May 1, 2018
PanGEO File No. 17-143.200

**Subject: Geotechnical Response to Review Comments
Proposed Residence
5236 West Mercer Way
Mercer Island, Washington 98125**

As requested, the following letter is provided to address review comments put forth in the City of Mercer Island Review Letter dated February 5, 2018, regarding the above-referenced project. Item numbers 22 through 26 of the Correction Notice concerns geotechnical subject matters, and are addressed below.

**SHORING AND TEMPORARY EXCAVATION PLAN**  
SCALE: 1/16" = 1'-0"

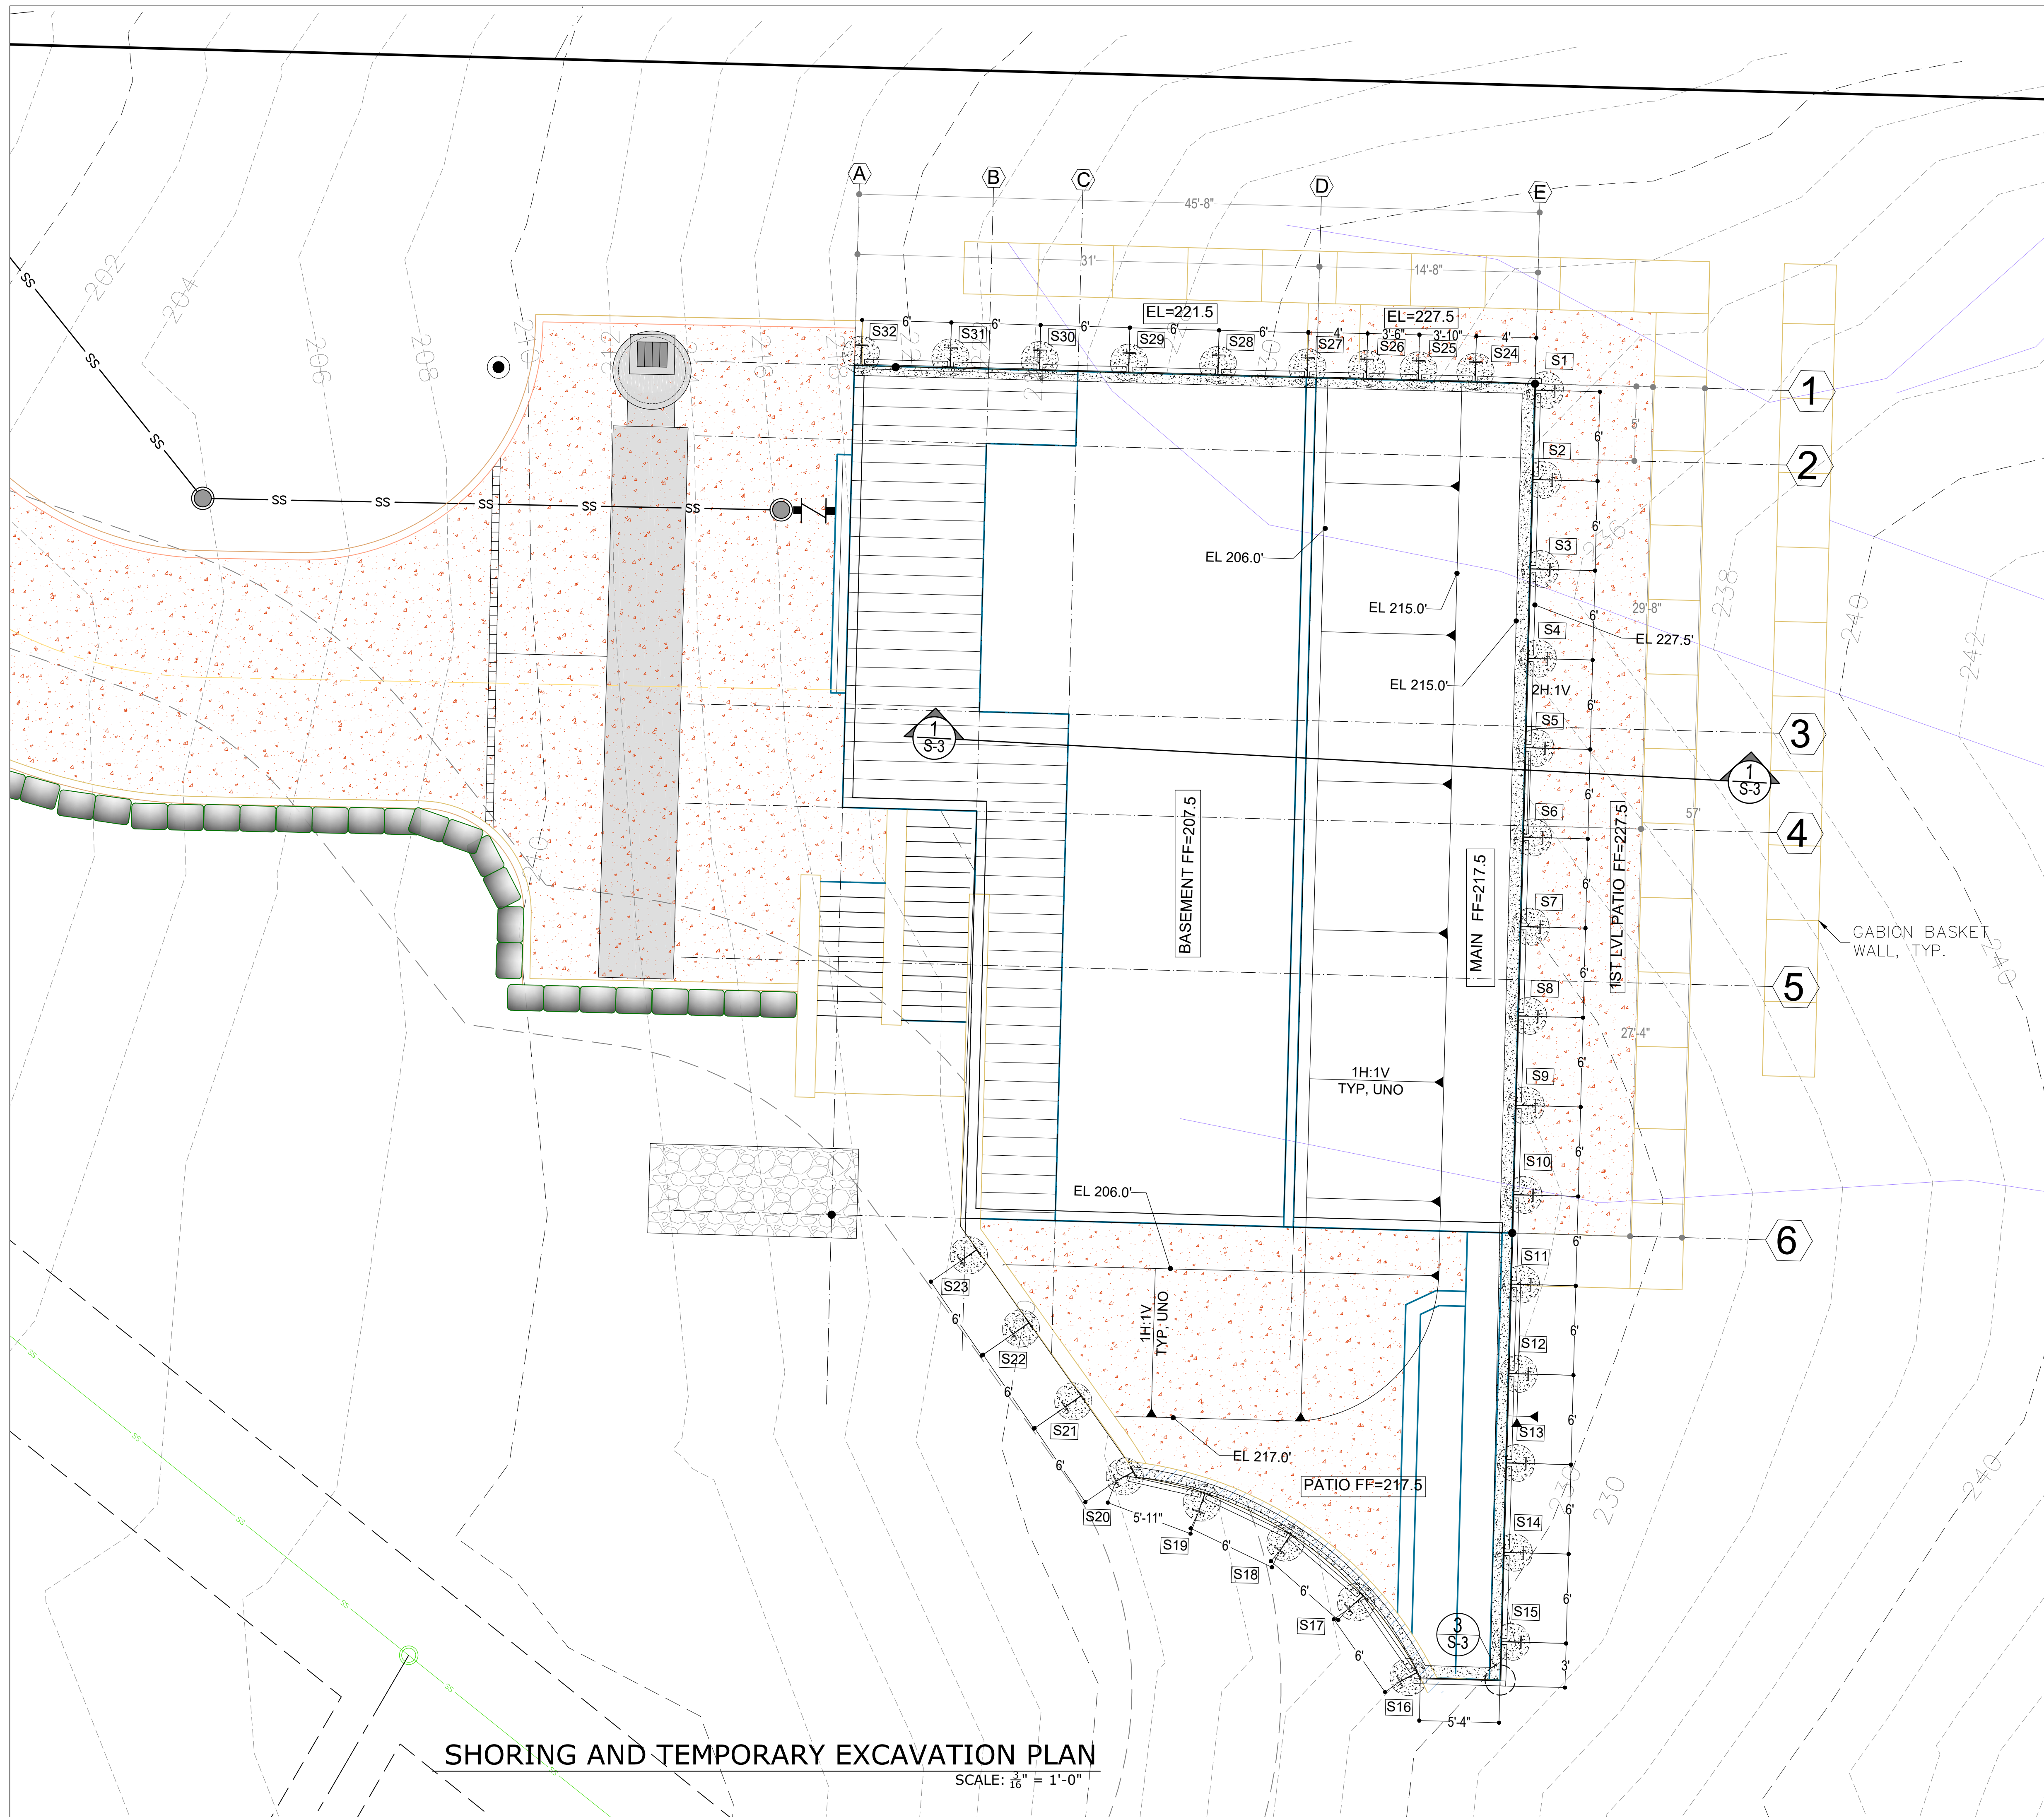
Items 24 & 25: Soils to be Exposed in Permanent Cut

As described above, the proposed permanent 2H:1V cuts to the north and east of the house have been replaced with gabion basket walls to significantly reduce the disturbed area of the site, and prevent grading from impacting tree protection areas.

The previously proposed permanent 2H:1V cut slope east of the proposed house has been eliminated and replaced with a tiered gabion basket wall. Our original report provided general recommendations for gabion basket walls at the site, however, we have prepared a specific gabion basket wall design for the sloping areas of the site north and east of the proposed residence. Please see attached Figure A for a typical schematic section of a gabion basket wall north and east of the proposed residence.
